OBJECTION: MIXED-USE DEVELOPMENT MACKENZIE ST, LAVENDER BAY SSD-88702457

I am the owner and resident of 12 Wilona Avenue, Lavender Bay. My home is an early 1900s single storey terrace and is identified as a contributory item within the Lavender Bay Heritage Conservation Area, it is directly across the road from the development site and is one of the properties most immediately affected by the proposed development.

MOBILE: 0410 699919
info@cadraftnsw.com.au

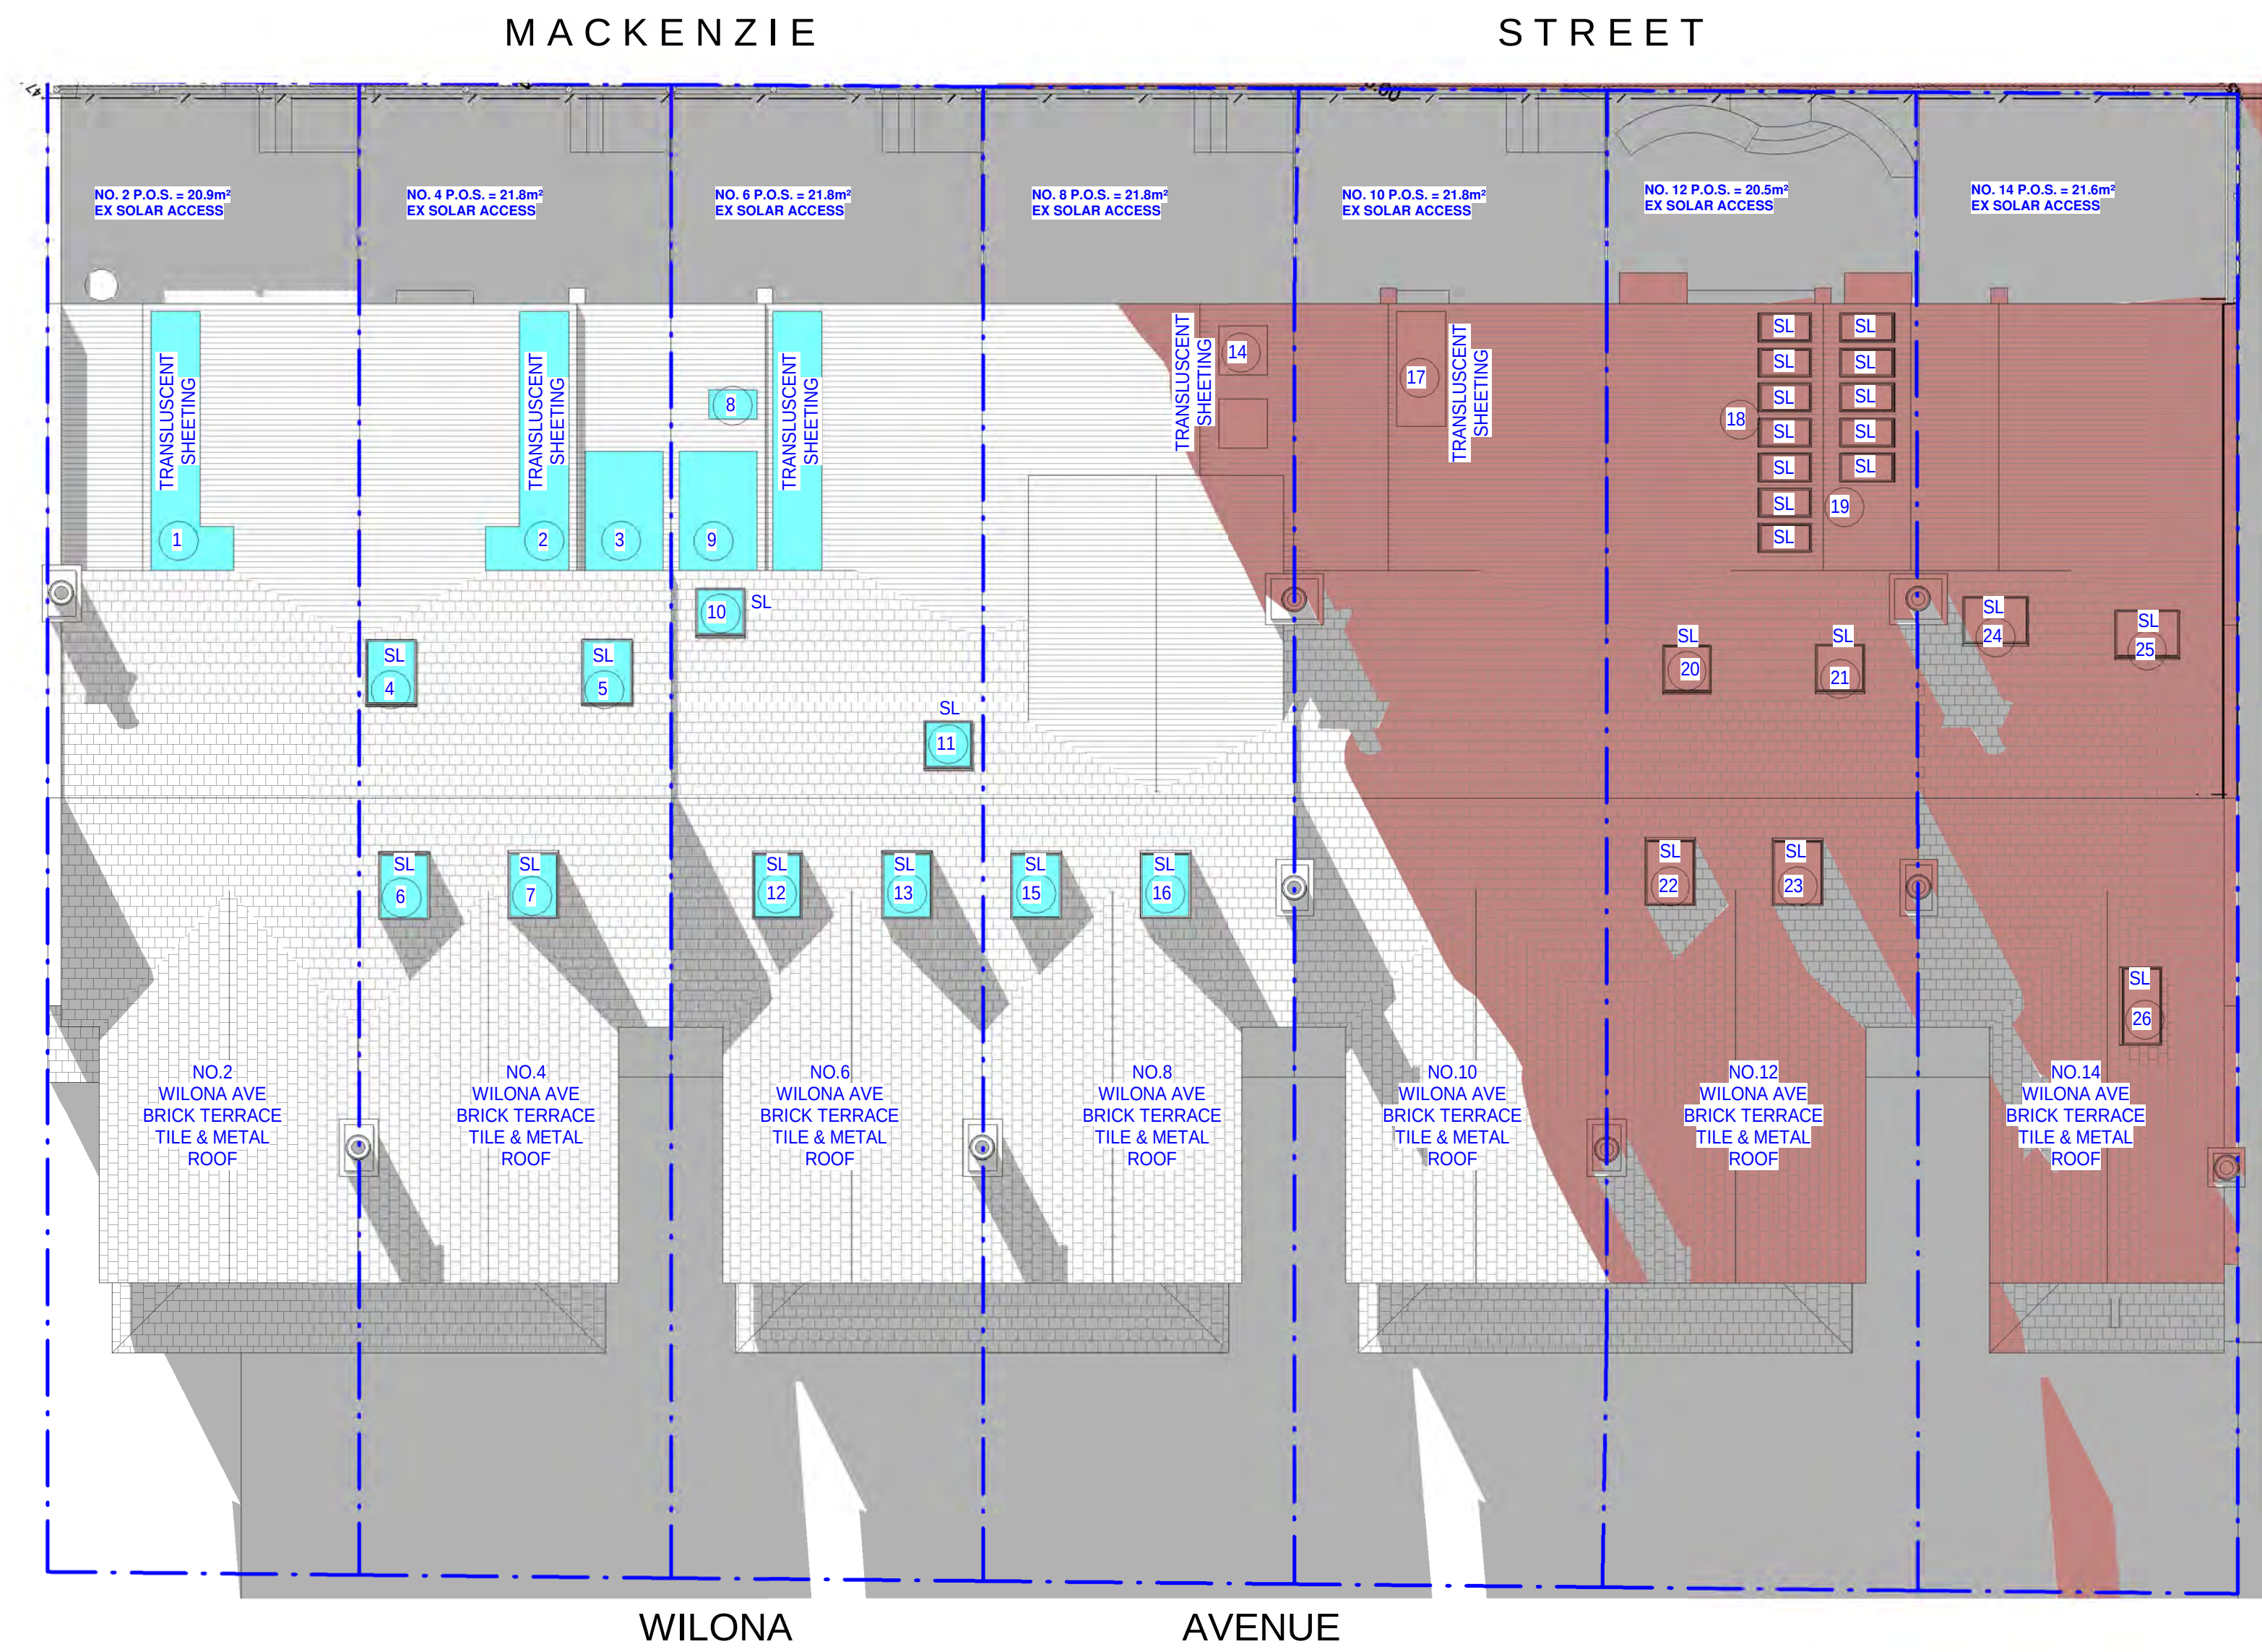
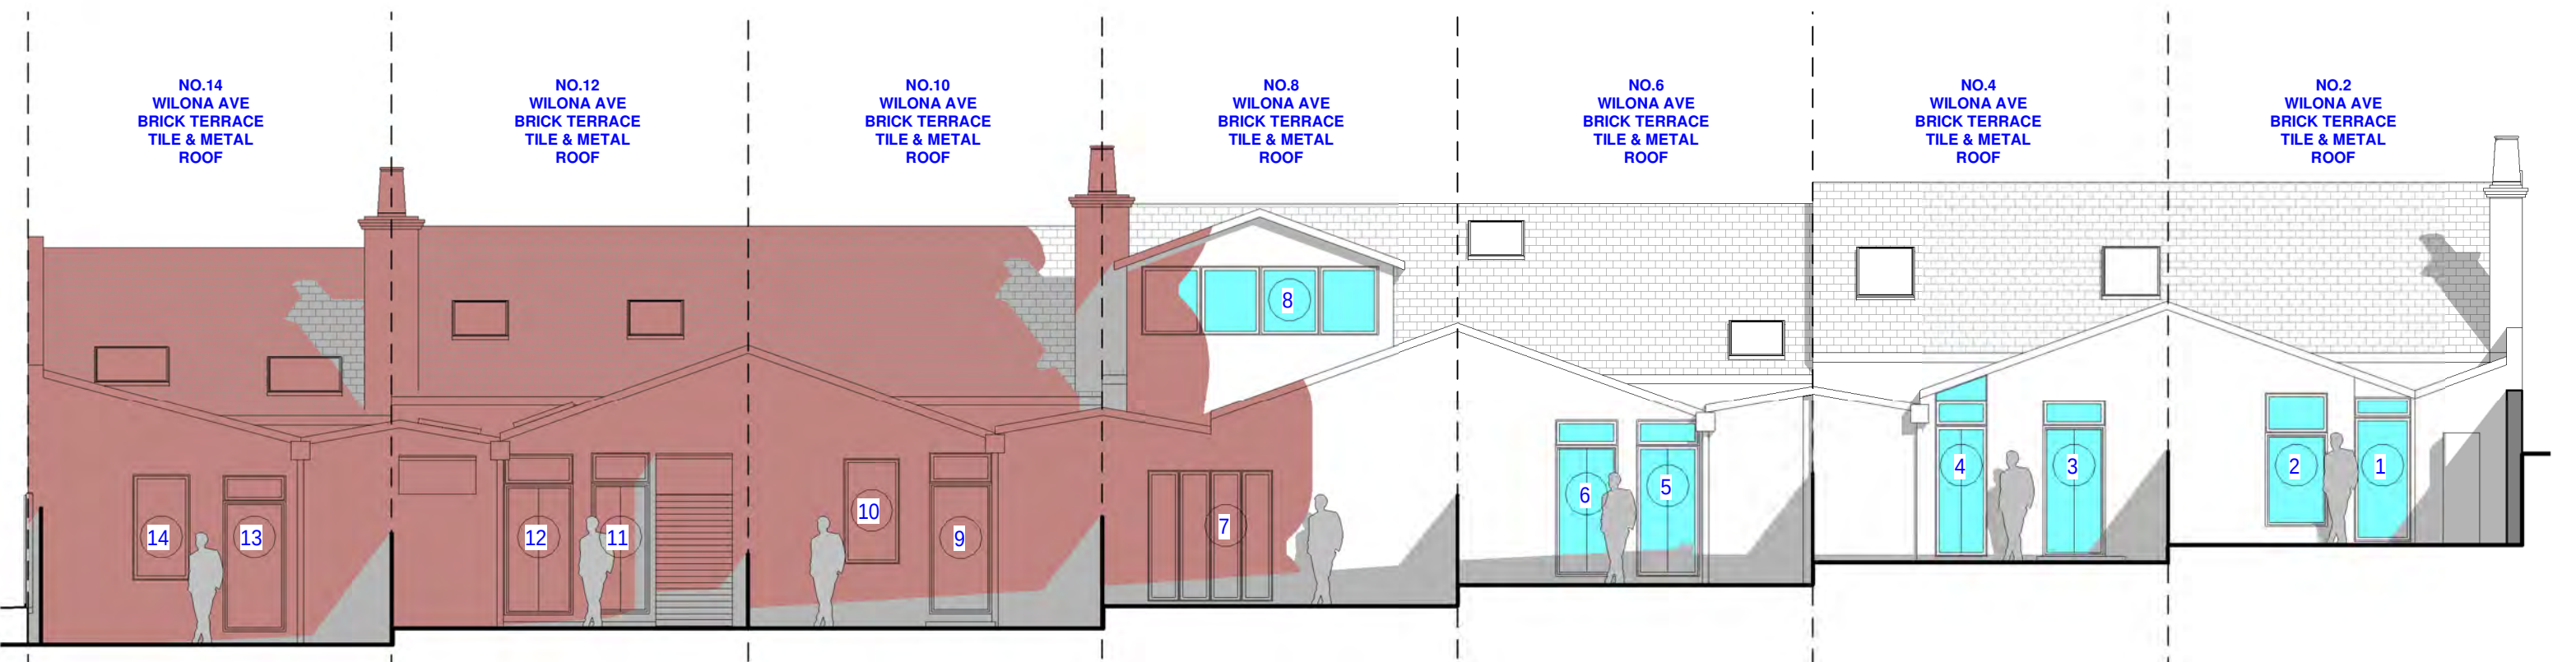
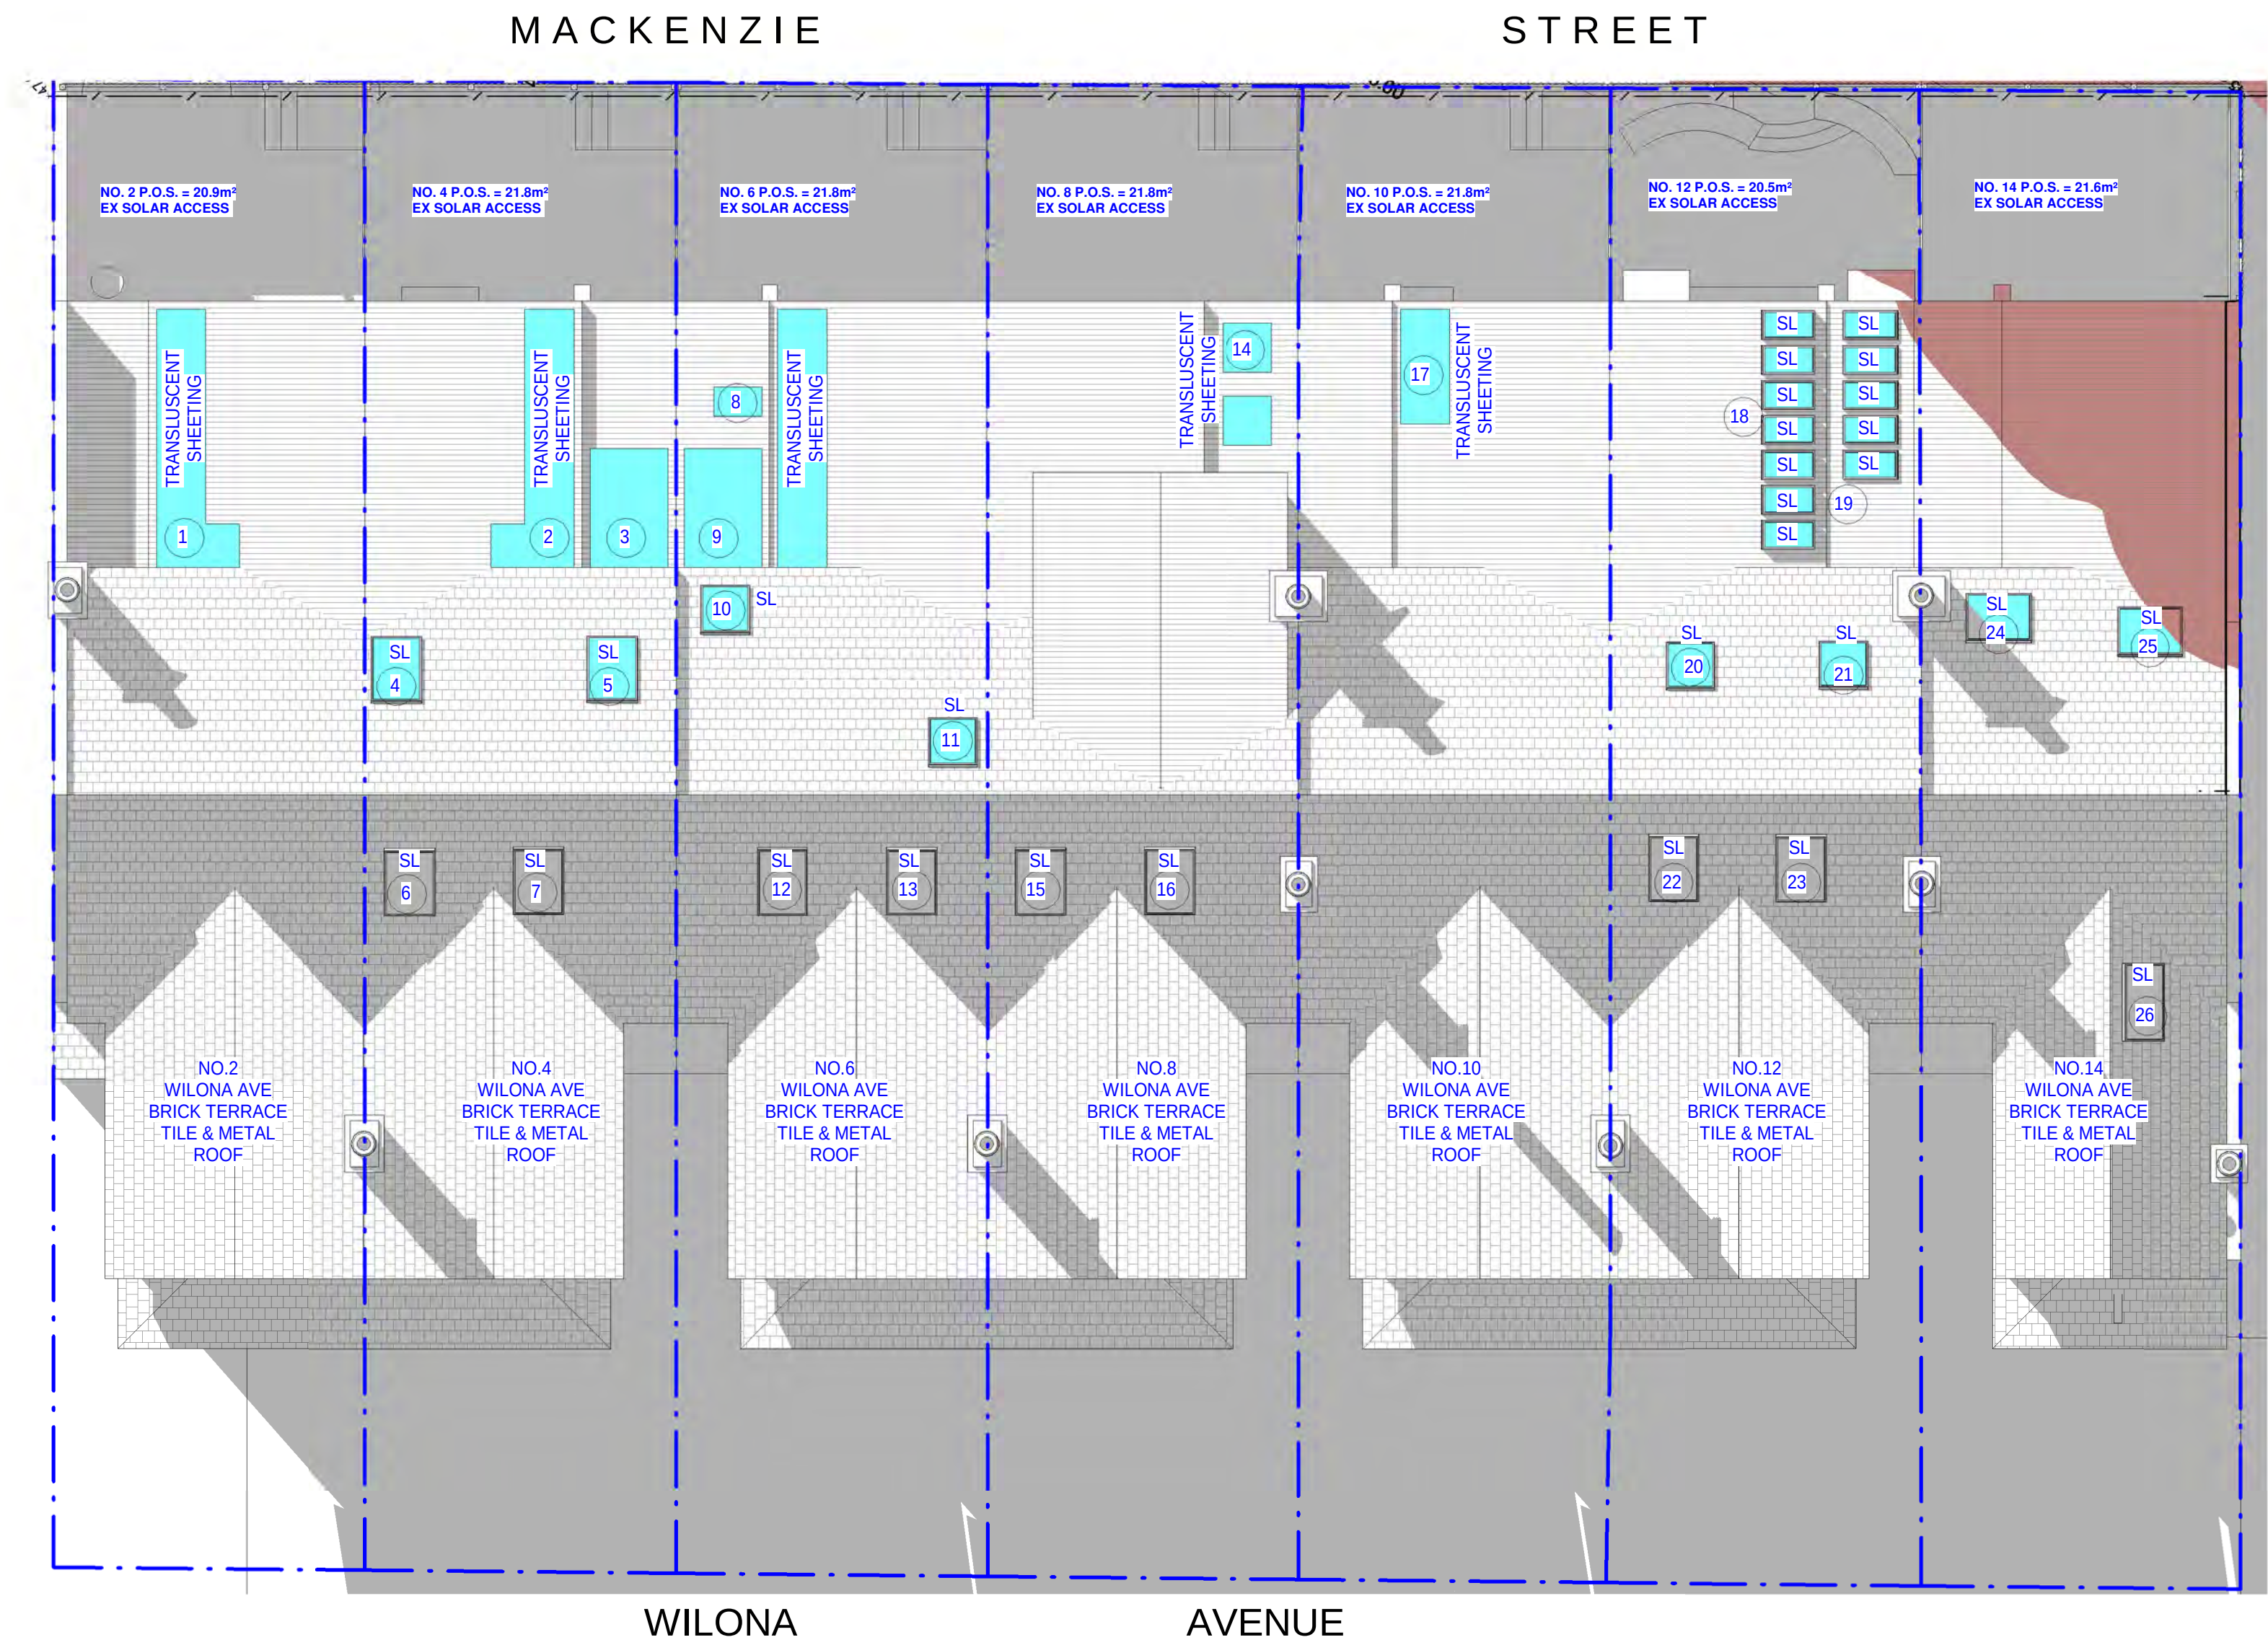
The loss of solar access to my home is another one of my strongest objections to this proposal. I live directly opposite the development and the independent solar analysis commissioned shows that the impact on 12 Wilona Avenue will be severe.

This is not a minor reduction at the margins. The proposed development will remove between 50% and 67% of the existing winter solar access to the windows serving my principal living areas. My main living area currently receives approximately 3 hours of solar access on 21 June and would be reduced to 1.5 hours. My kitchen currently receives approximately 6 hours and would be reduced to only 2 hours. These two spaces are used most frequently in our home, they are both our main living areas perhaps because they are the two areas with solar access. Being a single storey terrace house solar access is limited to the centre and southern side of the house our main living area naturally exist in the northern side of the house and we spend the majority of our time there.

The effect on the skylights that provide natural light to my home is even more serious. Of the six skylights/roof areas assessed at No. 12, five lose between 60% and 100% of their existing winter solar access. Two lose all of it, reducing from one hour of direct sunlight to zero. The remaining skylight still loses 50%.

The elevations show people standing within the courtyards and allow the shadow to be assessed at human height, not just at ground level. The northern elevation specifically includes No. 12 Wilona

Avenue and shows the relationship between the additional development shadow and the areas actually occupied by residents.
